# Board Order ABP-316828-23

**Application** by National Transport Authority for approval under section 51 of the Roads Act 1993, as amended, in accordance with plans and particulars, including an Environmental Impact Assessment Report and Natura Impact Statement, lodged with An Bord Pleanála on the 28<sup>th</sup> day of April, 2023.

**Proposed Development:** Construction of the Tallaght / Clondalkin to City Centre Core Bus Corridor Scheme, which has an overall length of approximately 15.5 kilometres from end to end with an additional offline cycling facility approximately 3.9 kilometres in length consisting of two sections, namely the Tallaght to City Centre section and the Clondalkin to Drimnagh section, comprising:

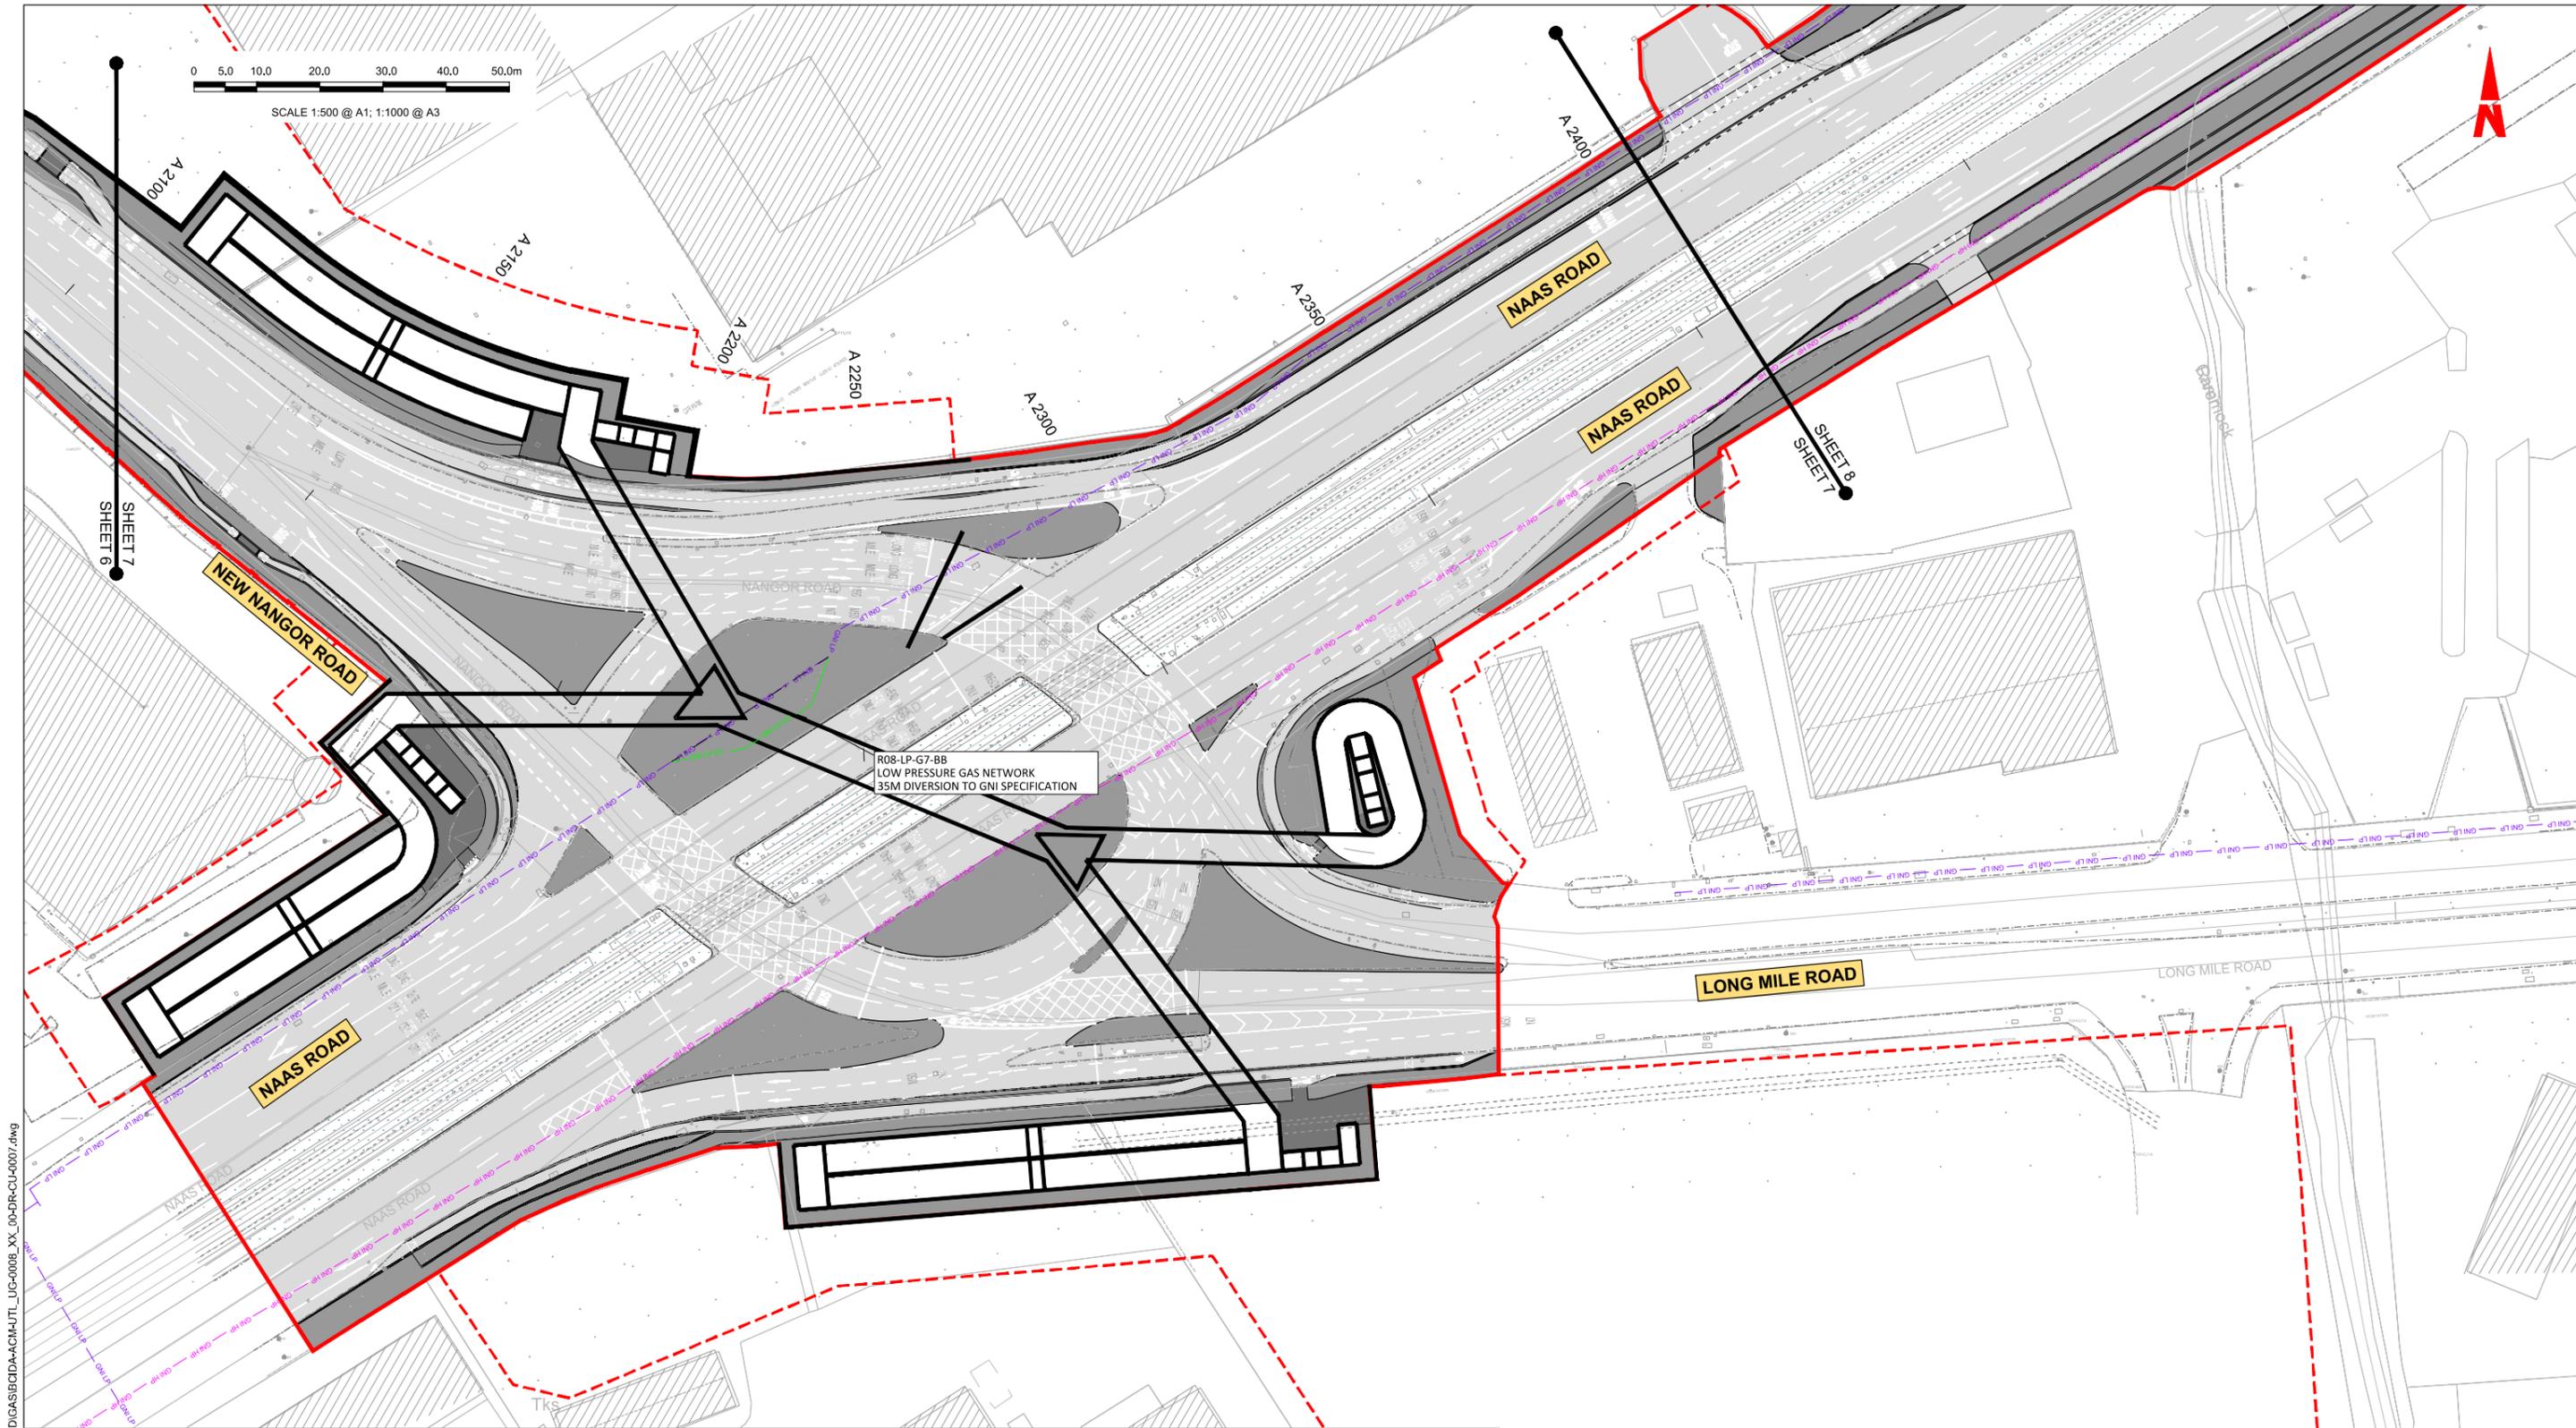
4. Prior to the commencement of the development the design and visual appearance of the pedestrian/cycle bridge at the intersection of Naas Road, New Nangor Road and Long Mile Road shall be considered further by the applicant and final design and visual appearance agreed in writing with the planning authority.
